**DEVIATION REQUEST
AND DECISION FORM IN
ASSOCIATION WITH A
REQUEST FOR A PUD
MODIFICATION FROM
THE ECM**

Project Name : Urban Landing Preliminary Plan

A deviation from the standards of or in Section **LDC 8.4.4 (E) (2)** and Section 2.2.4.B.7 Fig. 2-17, Table 2-7 and Section 2.3.8 of the Engineering Criteria Manual (ECM) is requested.

DESIGNED BY	MAW	SCALE	DATE	8/29/24
DRAWN BY	MAW	(H) 1" = 50'	SHEET	1 OF 3
CHECKED BY		(V) 1" = N/A	JOB NO.	1308.01

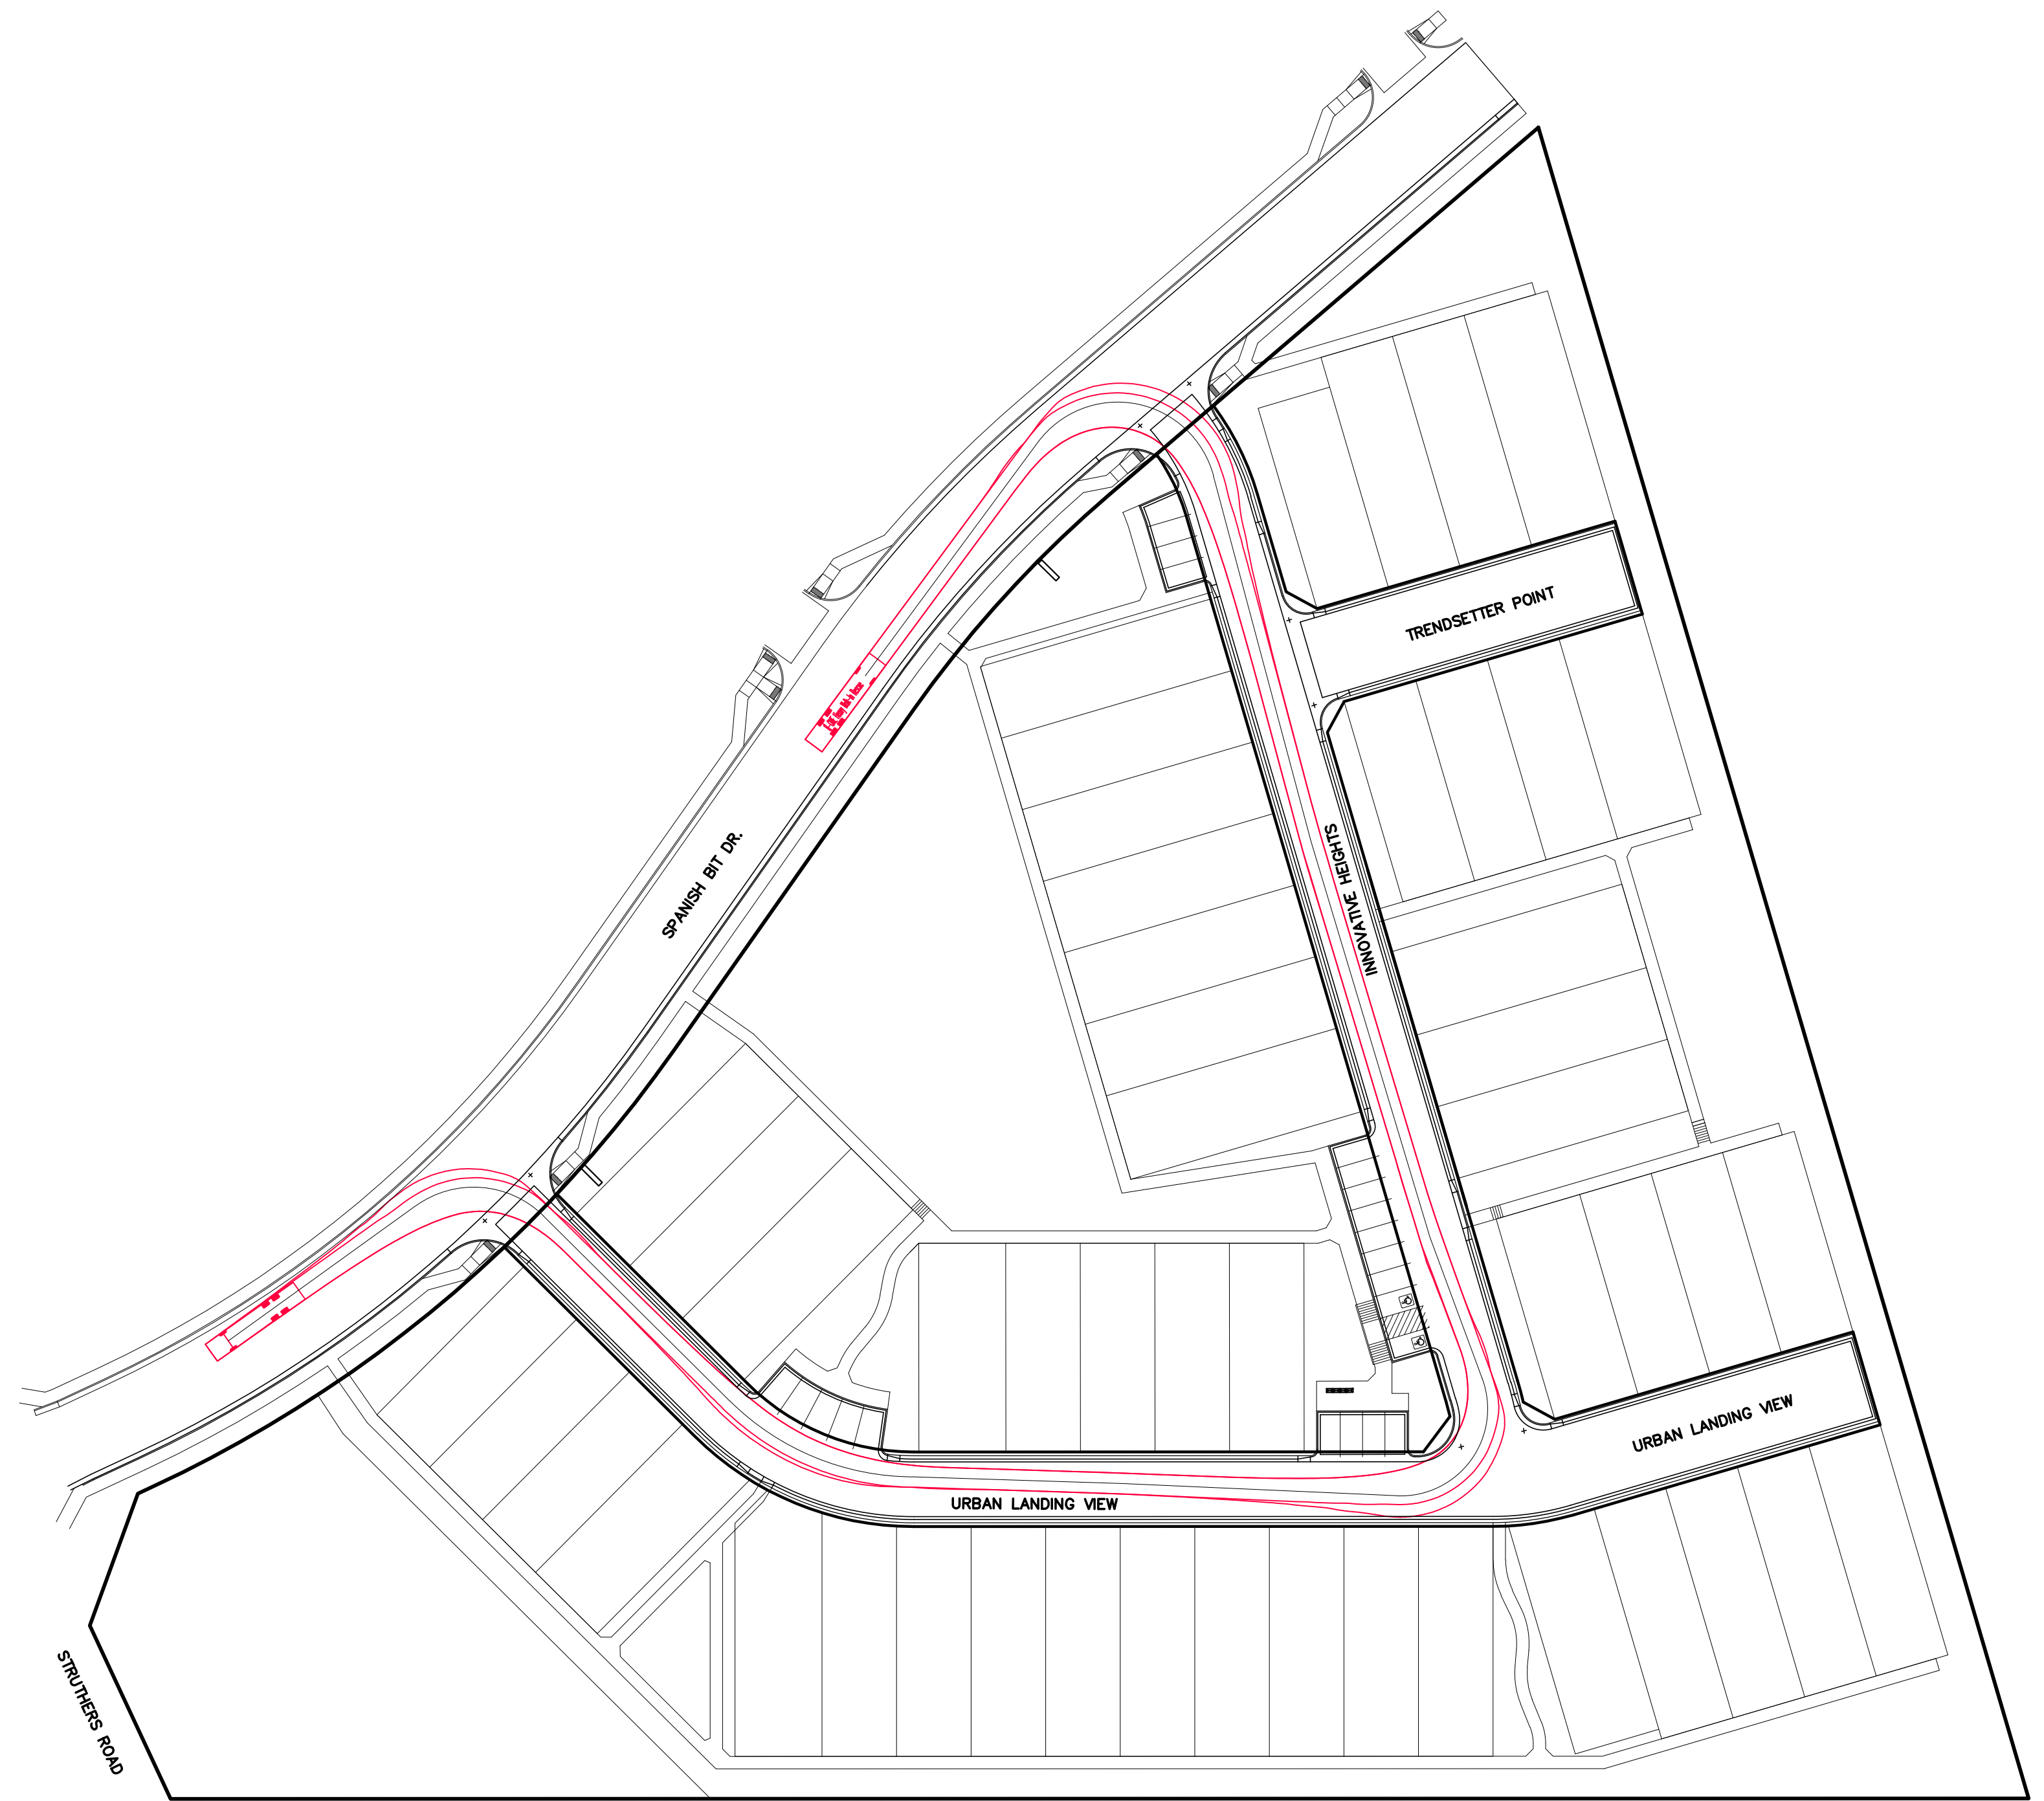
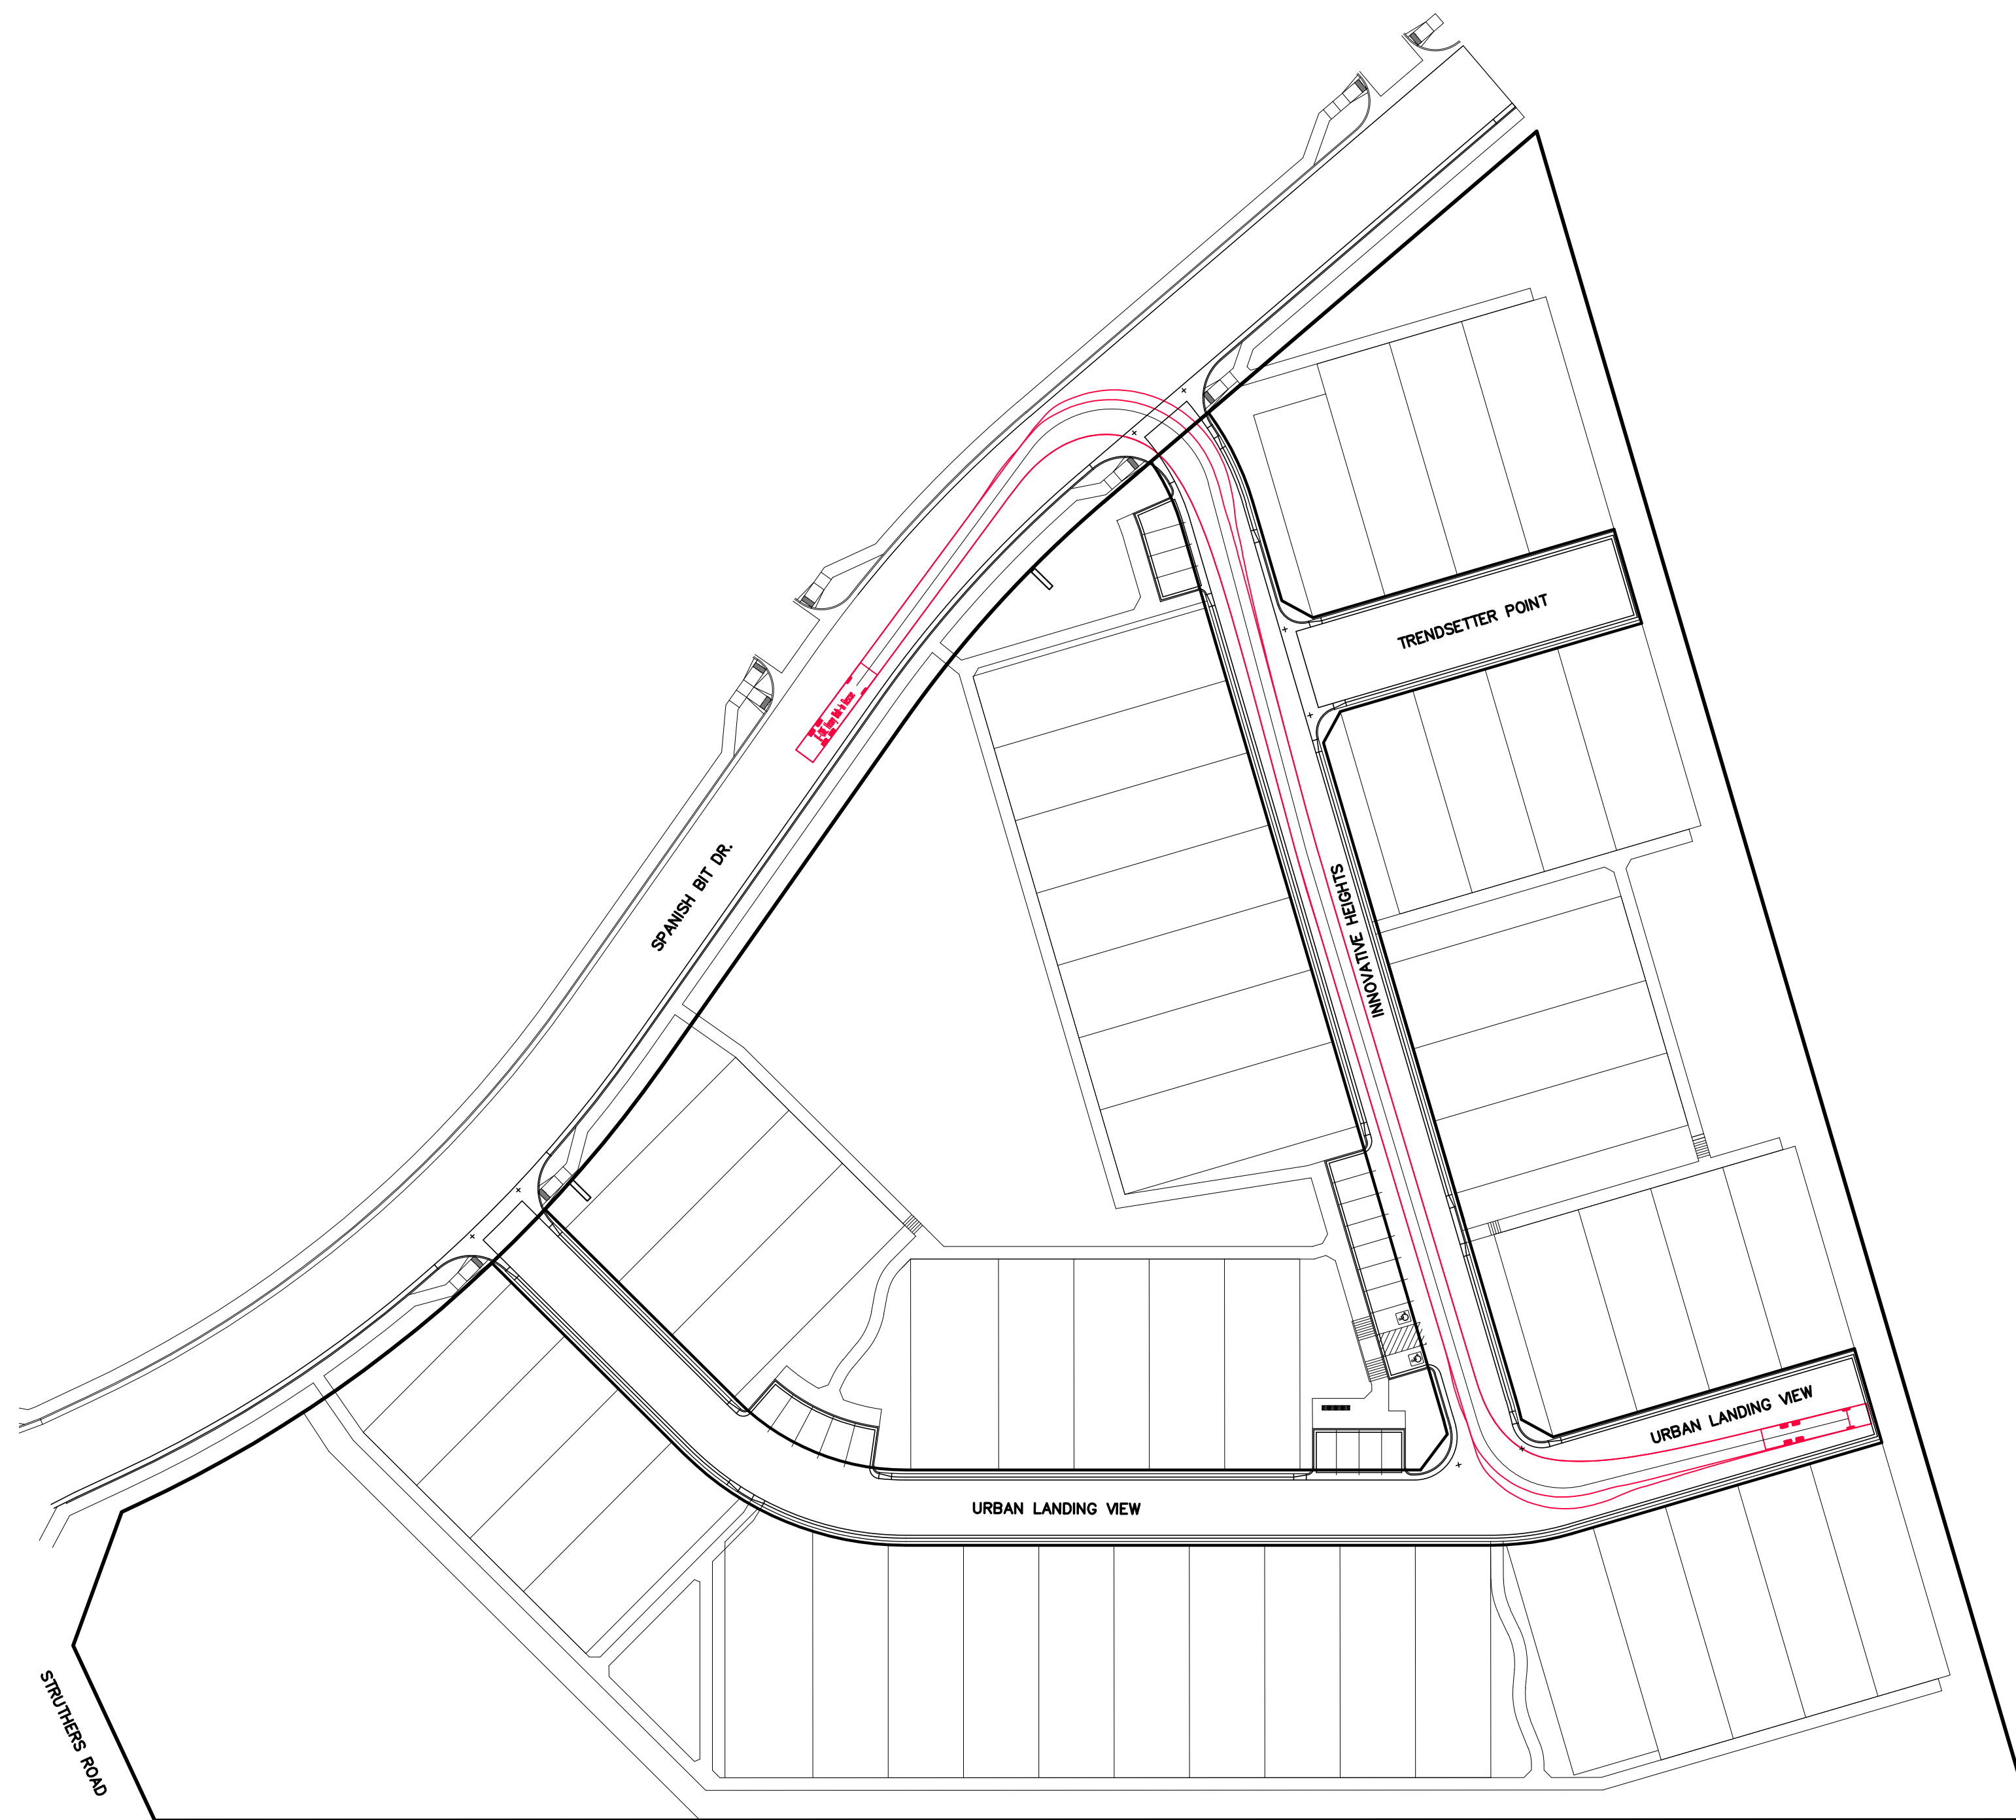
The unique community attributes include a high percentage of open space (30%+) that is the result of the private street use and rear garage access. The front doors of the applicable communities all face green belt open space corridors with pedestrian access from sidewalks within these corridors rather than along the private streets. The reduction in asphalt width has no impact on access or emergency vehicle maneuverability, as discussed with the Monument Fire District and provided fire truck access/turning movement exhibits. Reference attached endorsement e-mail from Monument Fire District.

No. They are short enough that it doesn't trigger a turnaround in the fire code.
